Planning Officer: Lynnyrd Wolfe

Planning Application Ref: A/148/19/T

Location: The Firs, Roundstone Lane, Angmering, BN16 4AT

Description of works: Reduce height and prune sides by up to 3m to 3no. beech trees, crown reduction up to 2m to 1no. ornamental cherry tree, crown reduction by 1.5m to 2no. deodora cedars

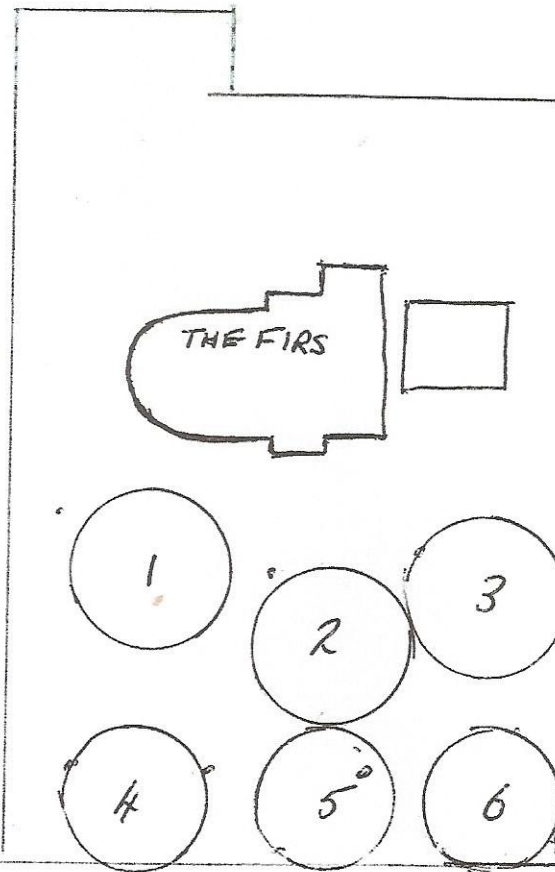
- **T1 and T2** – The tree work proposed in the application has not been justified on arboricultural grounds. This tree type is intolerant of hard pruning and the extent proposed would be damaging to their ongoing health and vitality.

T1 is a significant feature in the local landscape and appears to be in adequately sound and healthy condition. The tree surgery proposed in the application would result in excessive reduction of the tree's landscape impact and undue detriment to the visual amenities of the locality.

There is limited public view of **T2** at present, but this will increase if the tree is left to develop naturally and so provide a significant long-term amenity. It is unusual for such a tree to enjoy the room to develop with no foreseeable threat of above/below-ground interference and is an ideal candidate to become a future landmark tree of considerable stature and visual amenity.

- **T3** - The proposal to reduce its overall height and spread with a view to restricting its growth is justified and consistent with previous works approved by the Local Planning Authority.

- **T4, T5, T6** – These trees have the potential to develop heavy and congested limb/branch frameworks if allowed to grow unchecked, such that they may suffer partial failure of the same.

The work proposed is necessary to mitigate risk of structural failure and so justified on arboricultural grounds.

- As it stands, I recommend **REFUSAL** for this application due to the unsuitability of work proposed for items T1 and T2.

- Crown lift to 2.5metres on all aspects.
- Reduce crown spread (lateral extent) on west aspect only, by maximum of 1.5metres.

- Crown reduction by maximum of 2metres.

- Crown reduction by maximum of 3metres.
